Comments against the Planning application: 21/03759/F Land east of The Leys, Adderbury

From: Steve & Julie Bateman, Culbone, The Leys, Adderbury, OX17 3ES

We strongly object to this Application for two large houses on land east of The Leys Adderbury.

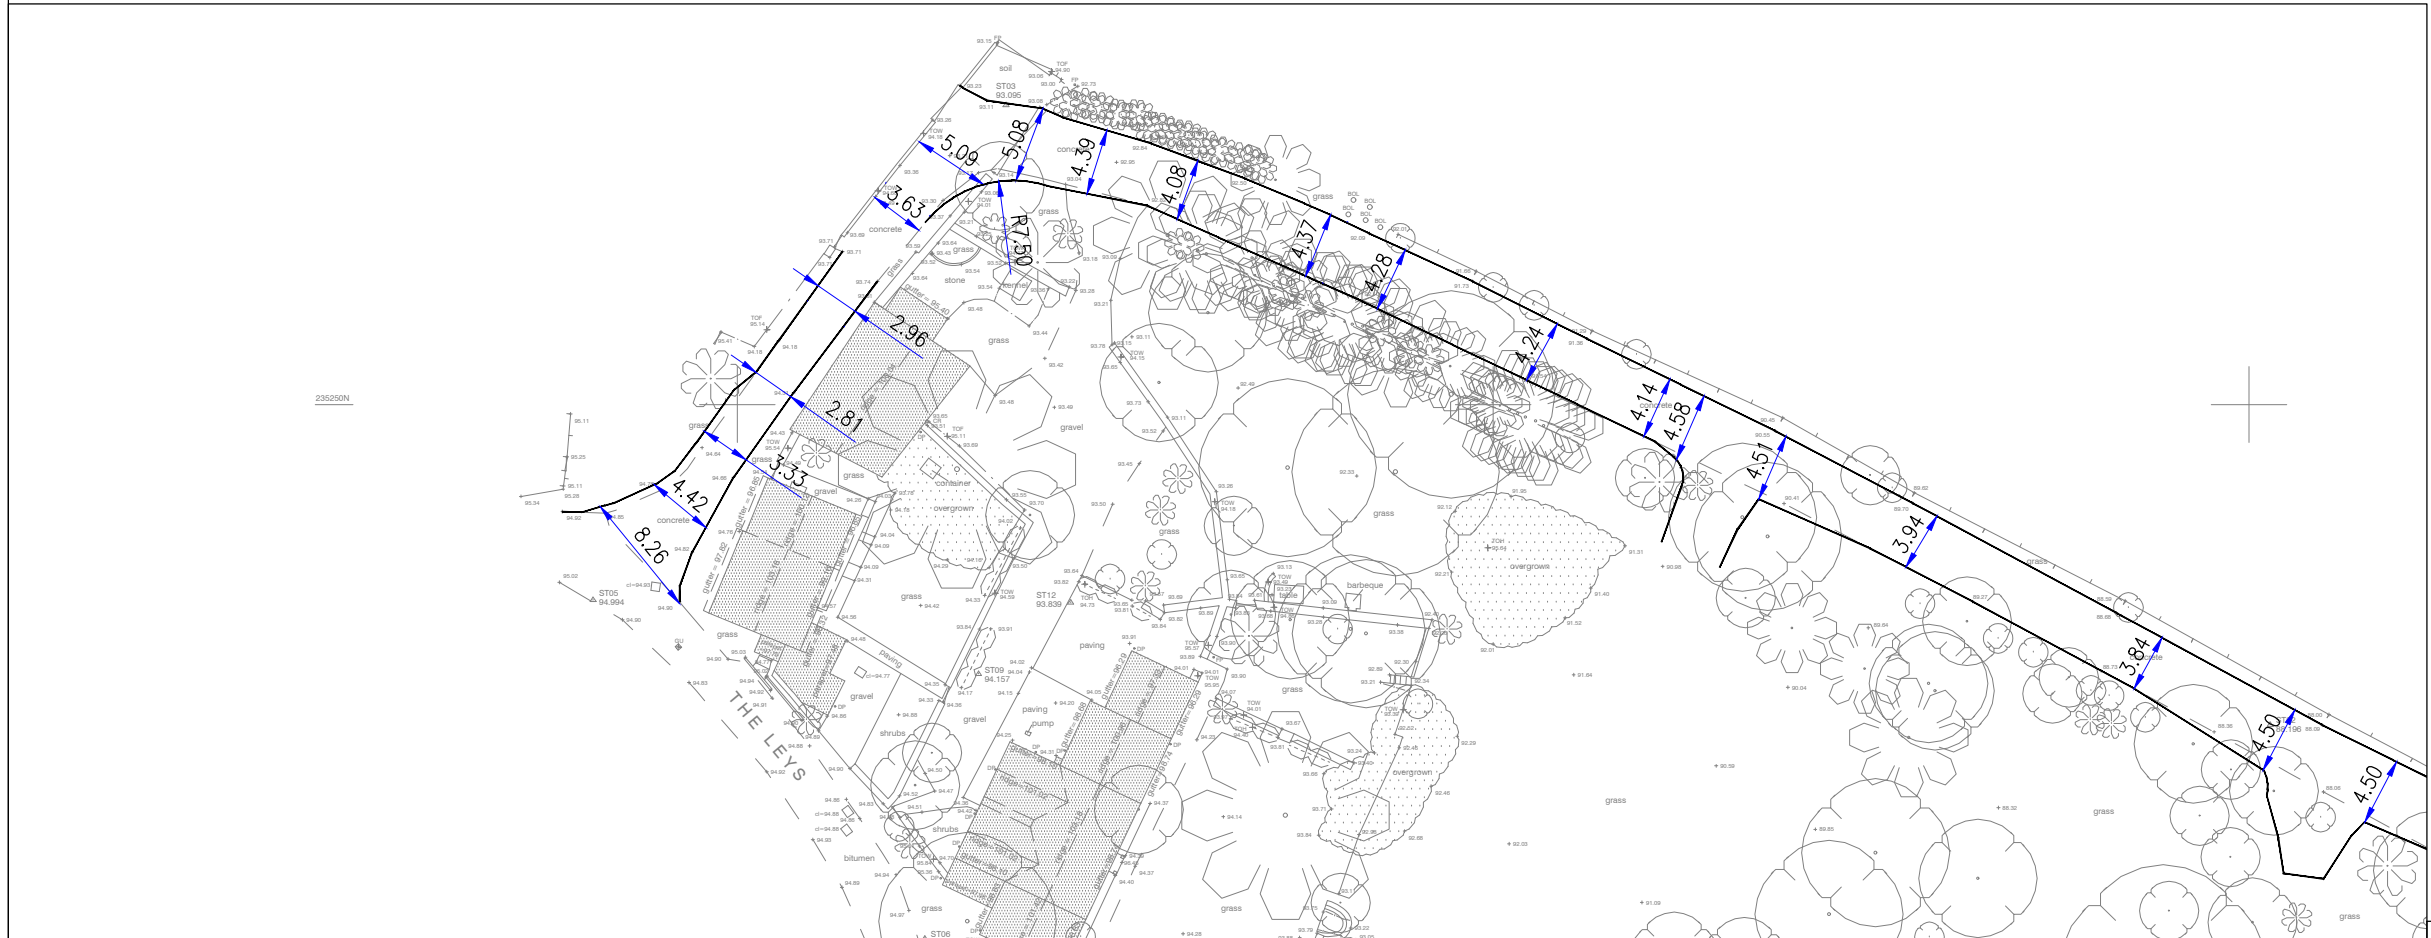
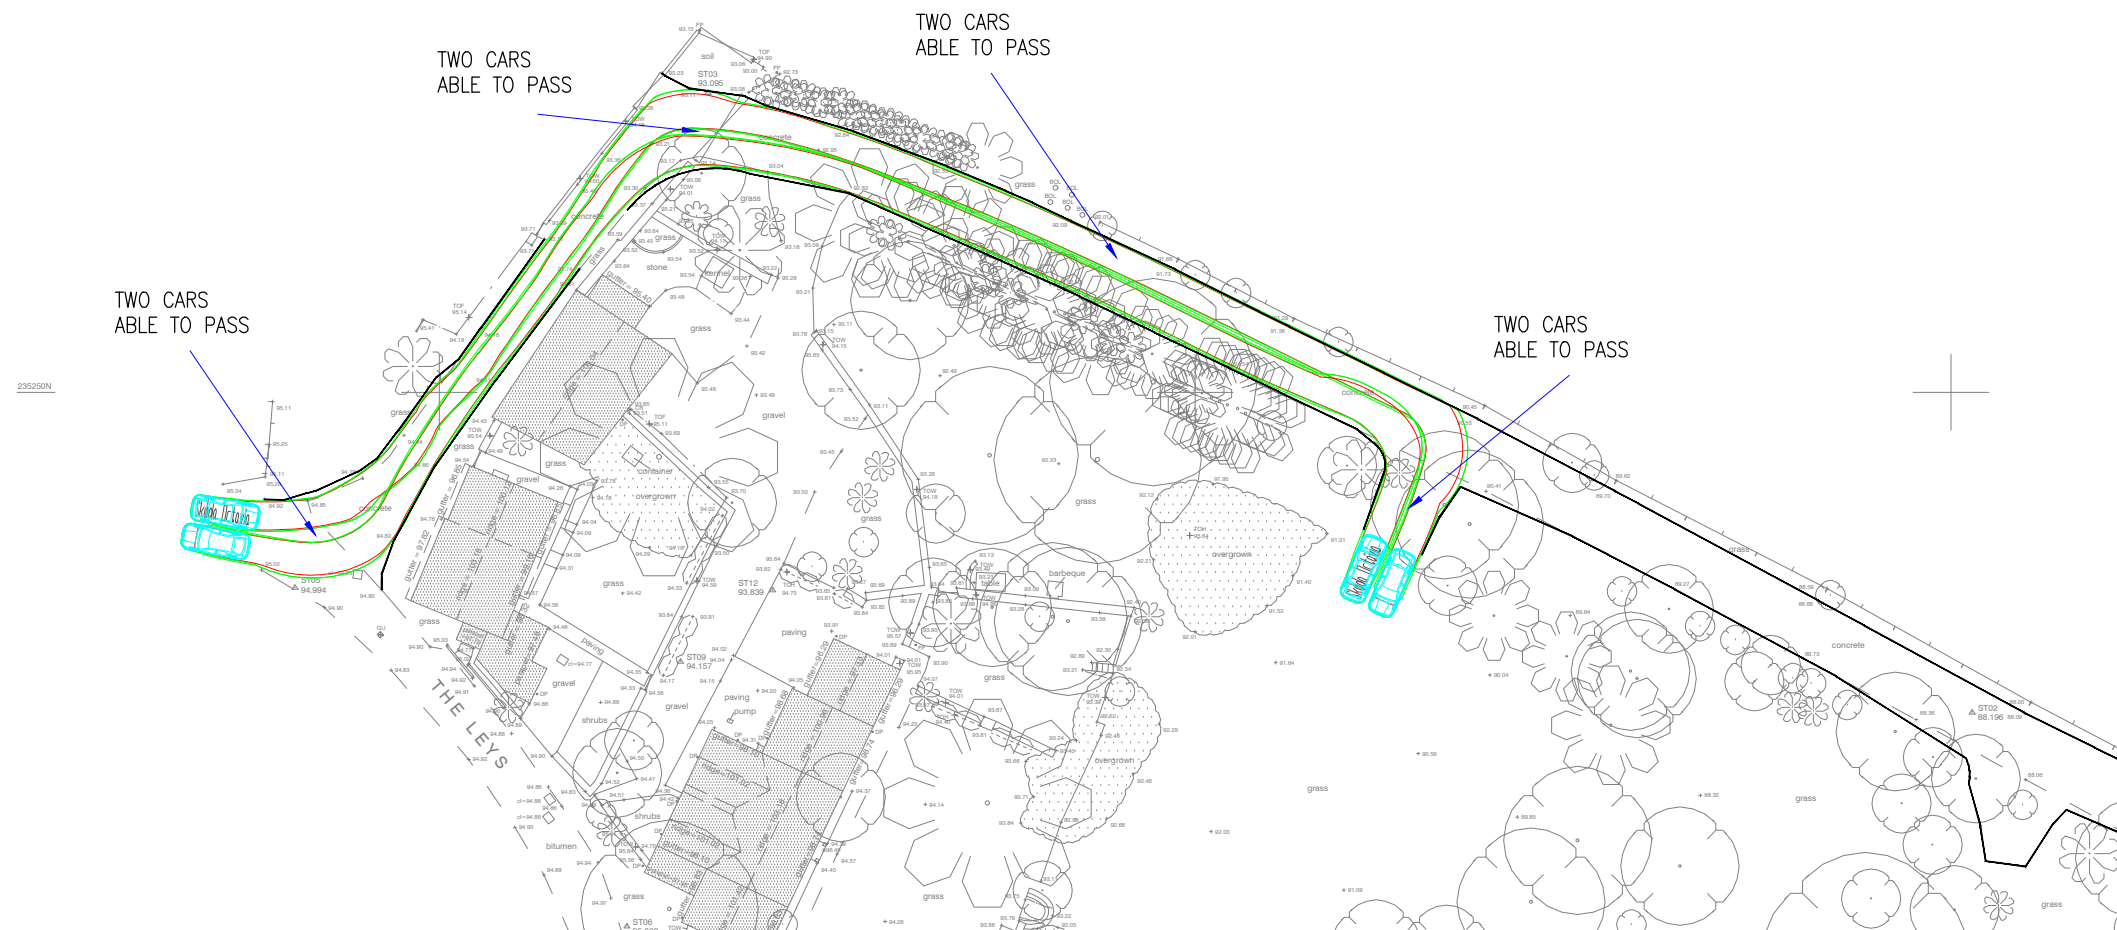
This revised application has still made only minor adjustments to the access road but they will not eliminate the need for reversing, nor possible conflict with pedestrians. Access to the proposed development via Tanners Lane and The Leys is unsuitable let alone the narrow single track access to the proposed development. This concrete drive is needed to access to the sewage works and is in regular use by vans and lorries maintaining the sewage plant. Tanners Lane is always congested with on street parking and there are no pavements for pedestrians. The Lane remains a popular and well used area for dog walkers and families with small children, walking to The Lucy Plackett playing-field, as well as walkers accessing other country footpaths and residences. Vehicles meeting on these lanes have to reverse to pass and at times it is necessary for pedestrians to climb grassed banks to allow vehicles to pass. With this in mind, it does not make sense to increase traffic to The Leys, without even considering the impact of any development construction vehicles! The large Plant and equipment necessary to clear this difficult to access site, together with general construction vehicles and multiple building materials deliveries will be unbearable for existing local residents and contrary to point 6.4 in the Planning Statement November 2019 prepared by Framptons, which glibly states that *"The proposed development will have no impact on the amenity of occupiers of neighbouring properties"*.

Drawing No: AA TL 01

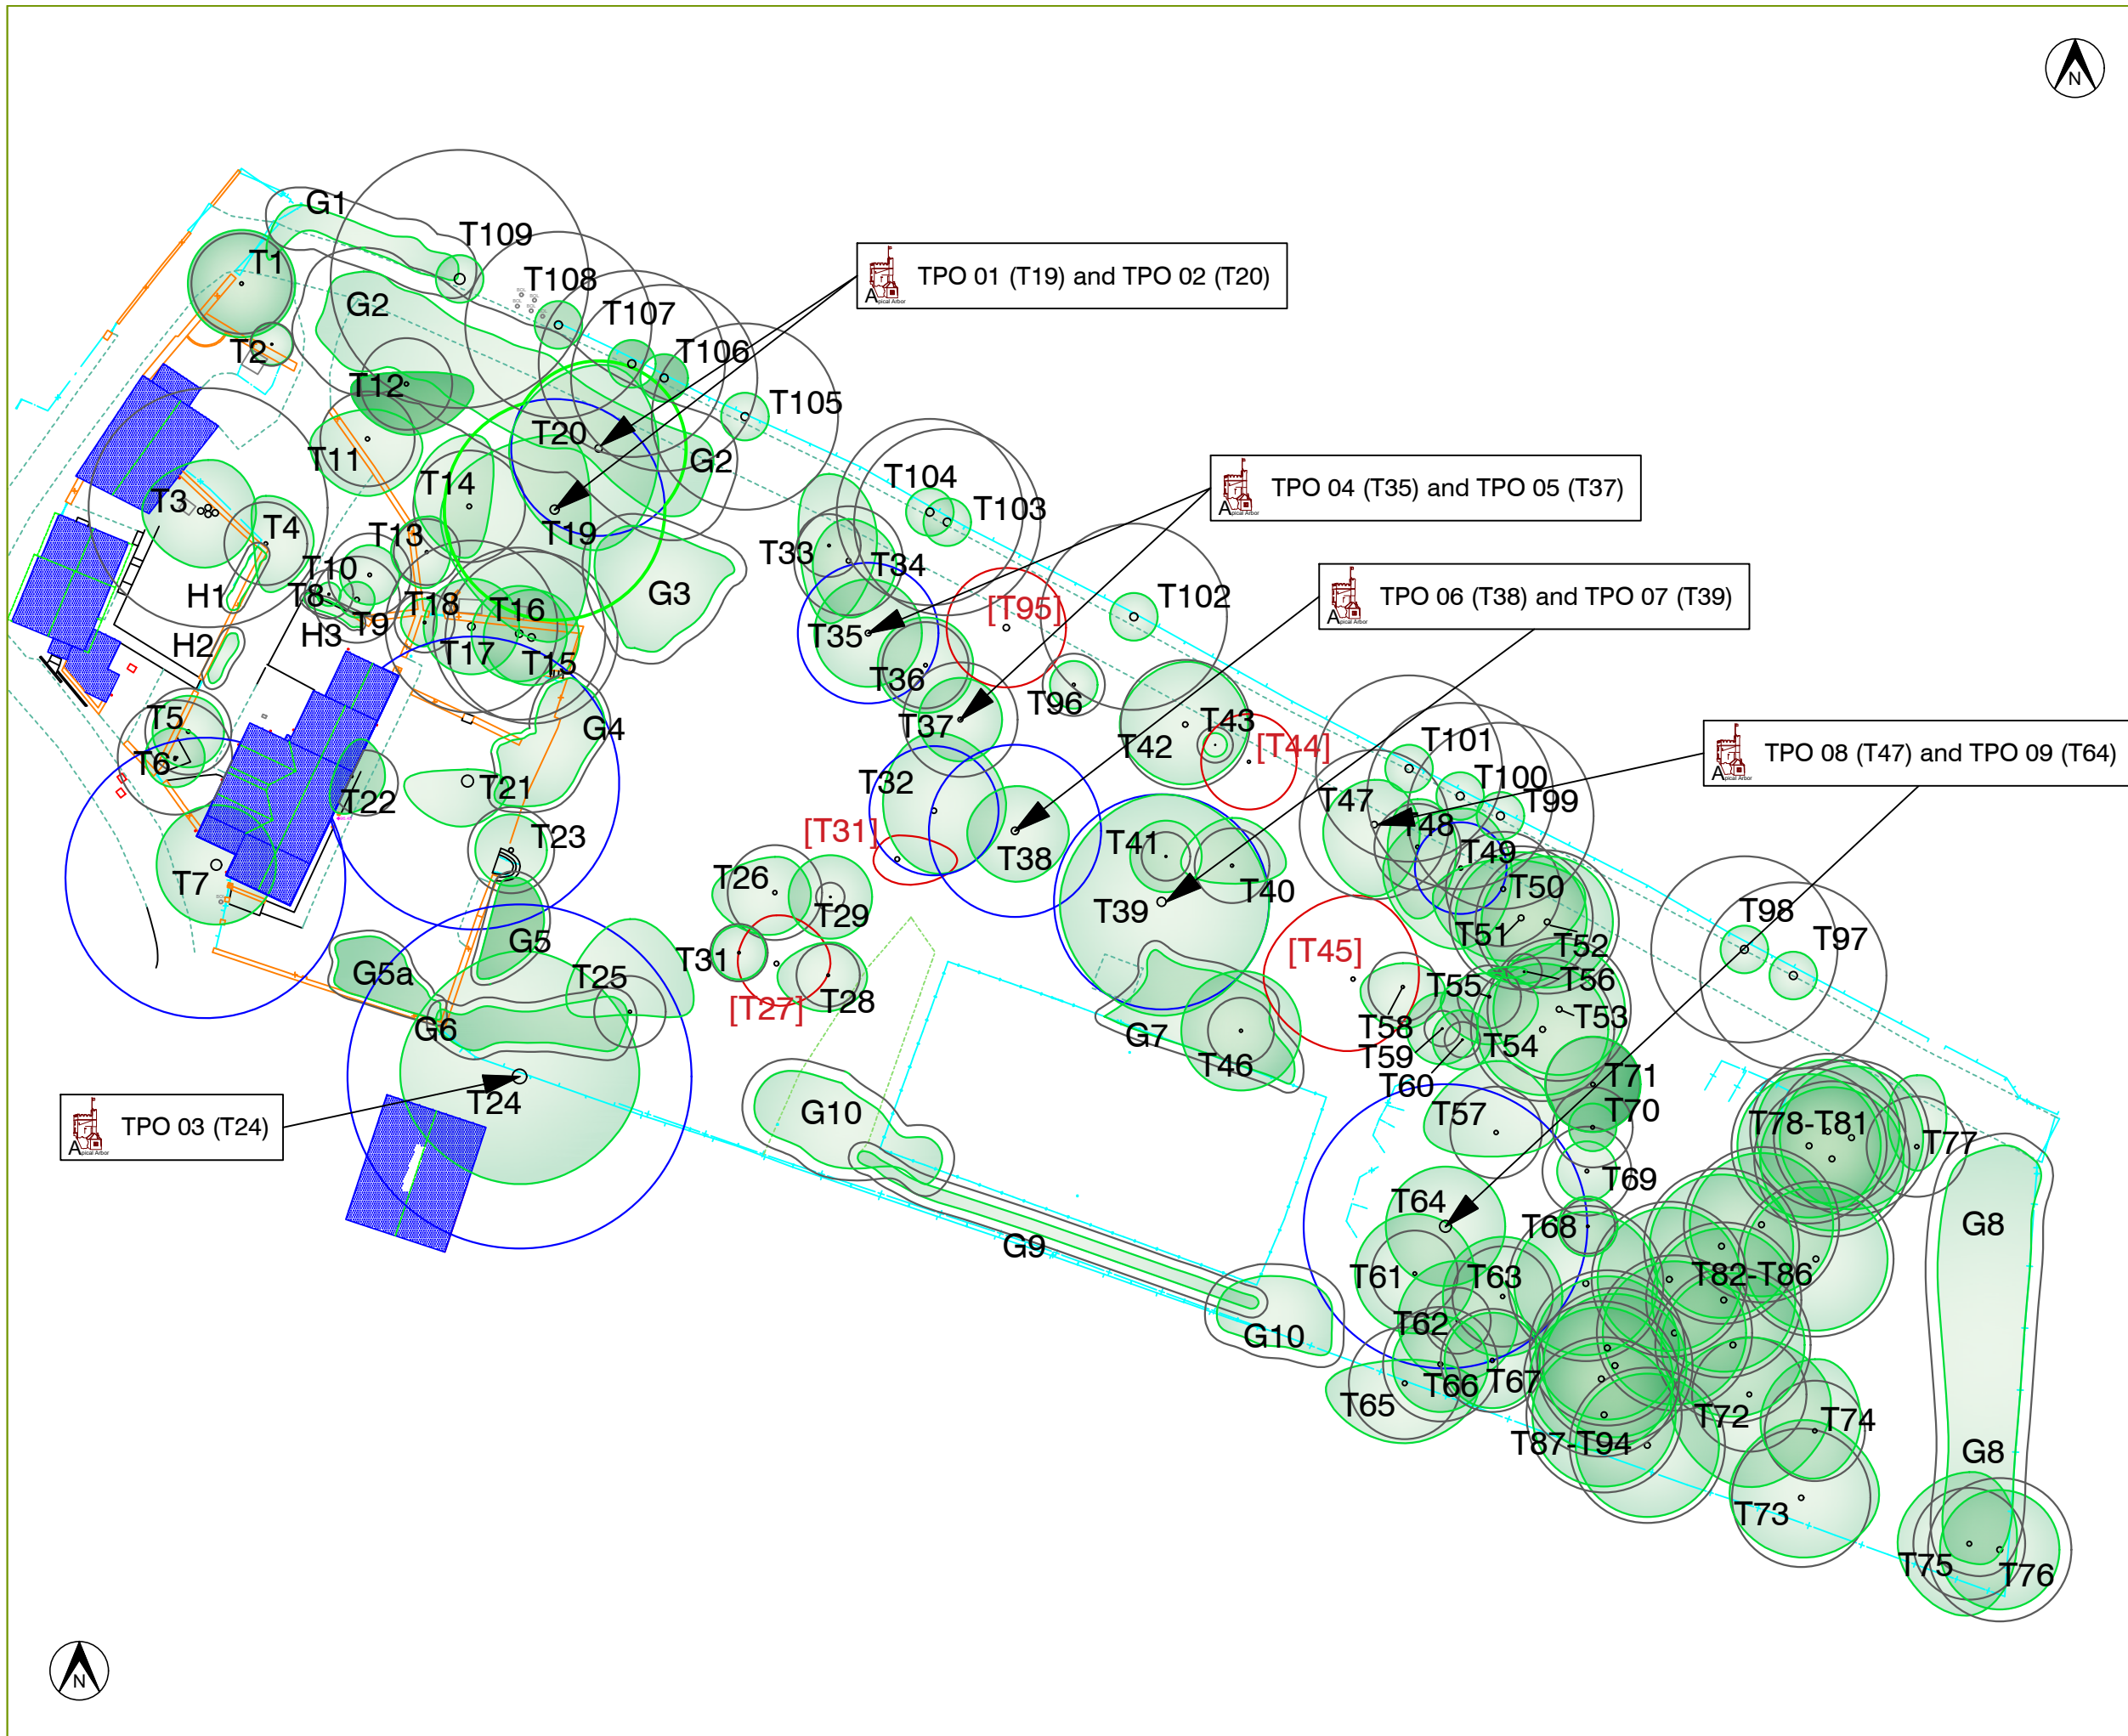
The 'neglected' garden as it is referred to, is full of diverse beautiful trees and plants which could have been maintained better and would potentially need to be ripped out and destroyed to facilitate this development. Some are now subject to Tree Preservation Orders but the application does not appear to have considered the full extent of the root system of the Old Oak Tree (marked as T24 on the Apical Arbor Tree Plan diagram).

Oak tree's have an extensive root system spreading horizontally, this lateral mass of roots bring the tree moisture and nutrients for its lifetime. Most oak tree roots lie only 18 inches under the soil, they spread to occupy a space four to seven times the width of the tree's crown. The plans only show protection of the area directly under the canopy (or crown) of the tree and does not allow for the fact that they will undoubtedly be across the area of the proposed Plot No.1.

We acknowledge the revised plans have moved Plot 1 a little further away from the oak but we still have distinct concerns about the impact of ground disturbance on this veteran tree. Culbone was built on a floating foundation to help safeguard the tree roots, if additional development was to be permitted in such close proximity we would have major concerns for the well-being and longevity of the oak and were it seen to demise, the possible impact on our own property's structural integrity. We will be seeking more professional advice on this issue and notifying **The Woodland Trust** as the Oak is on their Veteran Tree List, as well as being subject to its own TPO.

Client	Mrs Biggam	Project	PROPOSED DEVELOPMENT OF LAND AT THE LEYS ADDERBURY	Drawing	PLOT 2 PROPOSED ELEVATIONS SHEET 1
Architect	Nicholas D Price 45 North Bar Street Banbury OX16 0TH Tel 01295 262952			Scale	1:100
				Date	January 2019
				Drawing No	5392.08

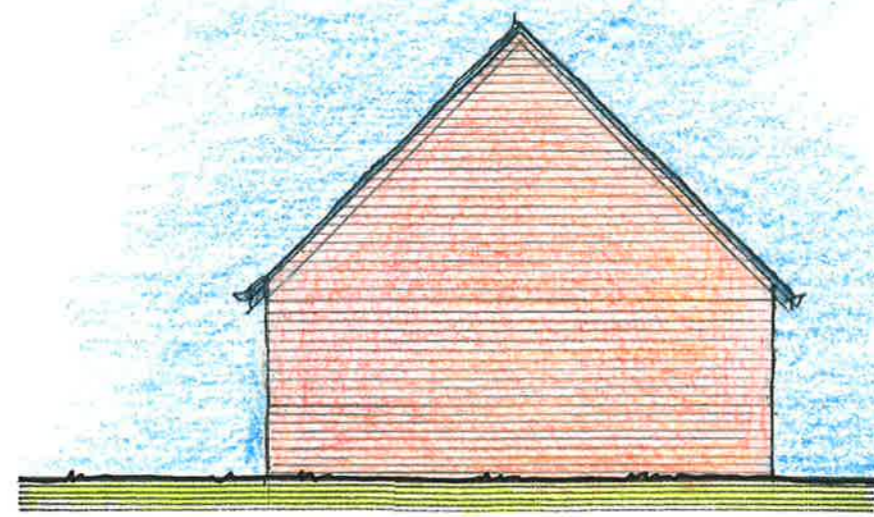
Having full length glass to the upper floor is particularly intrusive. In particular the proposed Plot 2 is a large imposing house, only a few metres from Culbone's boundary fence - directly over looking Culbone's garden. Examining the floor plans you have to question the positioning of the windows in bedroom 1. The main windows to this room could easily be put on the front elevation! Bedroom 5 has a window directly overlooking Culbone's garden, which is a secondary window to this room and therefore for the size of the room completely unnecessary. Furthermore, we see no stipulation in plans for the Bedroom 2 en-suite window to be frosted? Not only are all these windows extremely intrusive on our garden, but ***we struggle to see what prospective purchaser would want to look out on sheds, stables, chicken house and an old greenhouse!***

Please also note the proposed site is on a gradient and as such means that Culbone (being in an elevated position) will look down directly into Plot 2. Not only is this undesirable to Culbone residents but surely potential occupants of the proposed property will share identical concerns around a clear lack of privacy? We do not feel the Applicant has considered the privacy of neighbours!
